u/87/19/PL  
**Nicola Spencer**

**From:** Nicola Spencer  
**Sent:** 01 May 2019 11:03  
**To:** [REDACTED]  
**Subject:** FW: Further Information Required on Your Ref: PP-06776872 Our Ref: LU/87/19/HH  
**Attachments:** scan\_nicola.spencer\_2019-04-12-13-02-47.pdf; scan\_nicola.spencer\_2019-04-12-13-03-43.pdf

**From:** Nicola Spencer  
**Sent:** 12 April 2019 13:22  
**ToSubject:** RE: Further Information Required on Your Ref: PP-06776872 Our Ref: LU/87/19/HH

LOCATION PLAN

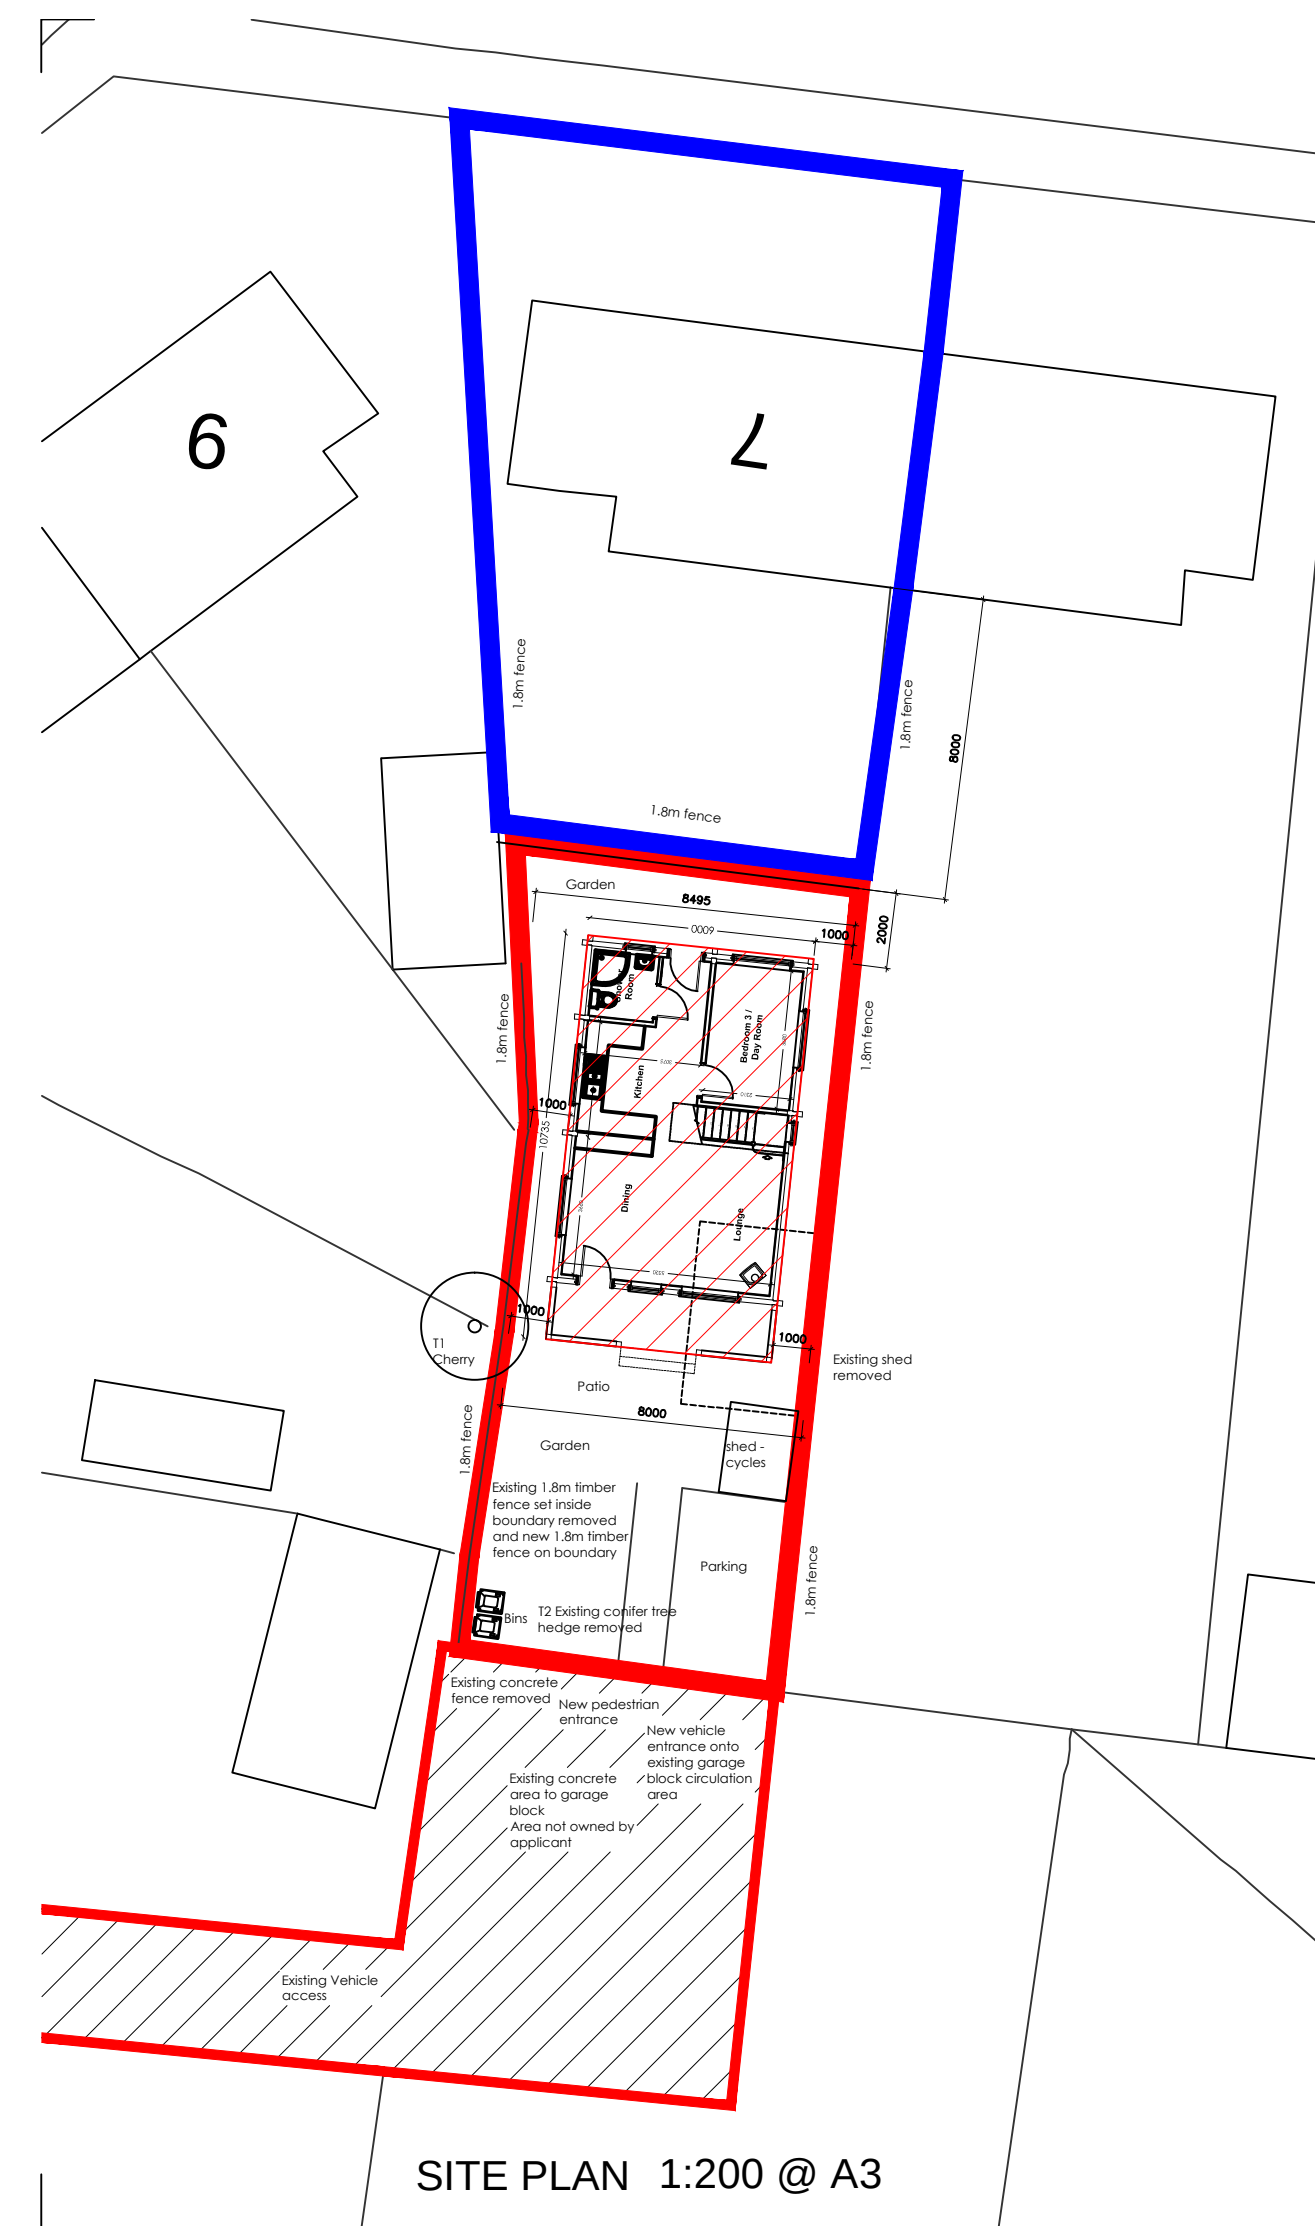
- 1 I am not sure if you are aware but all the plans you submit will form part of the planning permission if it is approved and you will have to build exactly to the plans. You have only roughly drawn the new dwelling and red and blue edges these need to be accurately drawn as we will measure from these plans.

- 2 The blue edge needs to be drawn onto the Location plan (1:1250 scale) not the block plan, (1:500 scale)
- 3 I am sorry but the access you have indicated is not correct. Basically the red edge would need to be extended to be around the area you have shown as hatched as the red edge must go up to the public highway. It is fine to hatch it to indicate it is the access, but it must be within the red edge and there should be a key indicating that the hatching relates to the access and indicate whether it is a vehicular or pedestrian access. If vehicular you will also need to show visibility spays which must also be incorporated into the red

BLOCK PLAN

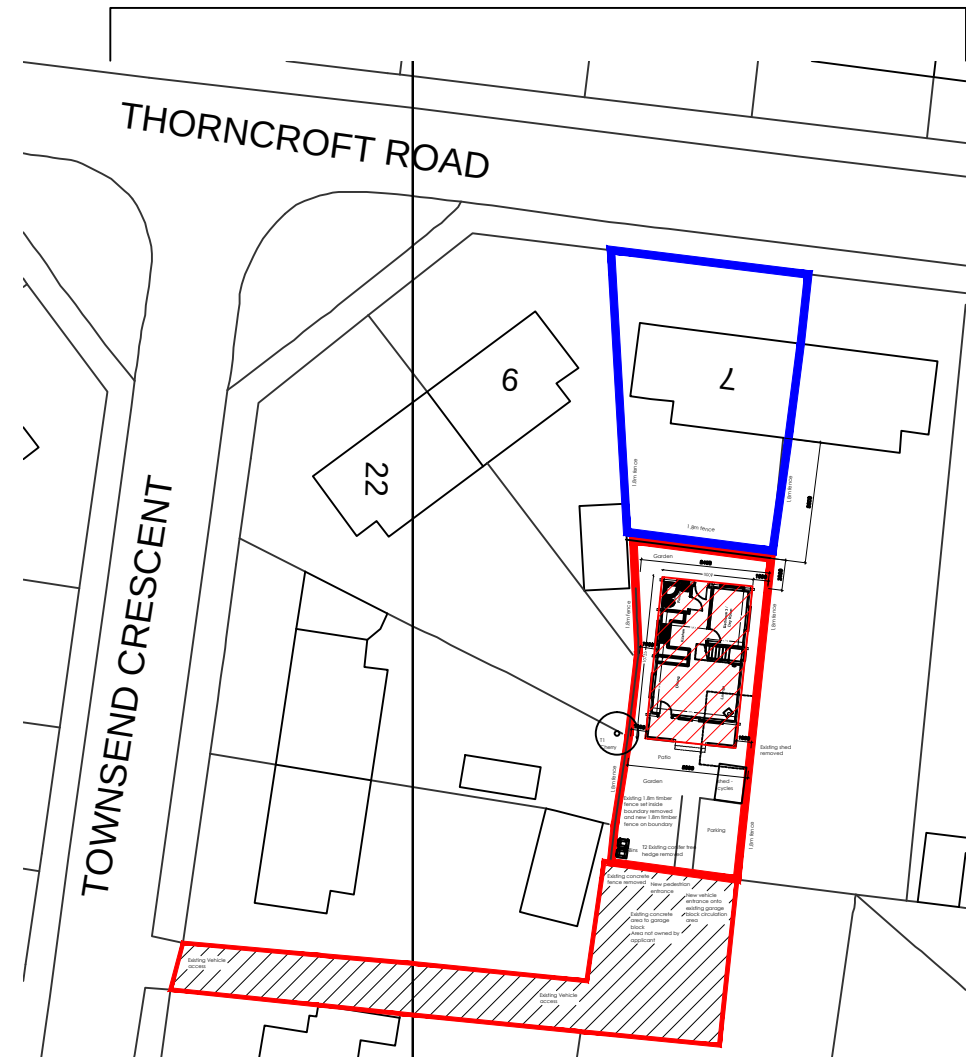
- 4 From the block plan it would appear that the visibility splays would encroach onto the properties either side of the drive way to the garage compound so you will need to complete Certificate B on the application form and return it to me and serve notice to both properties. I attach a certificate for you to complete and a notice form which you can use to serve on the other landowners.
- 5 From our telephone conversation you indicated that the garage compound was owned by West Sussex County Council so you will have to serve notice on them as well or whoever owns the compound.
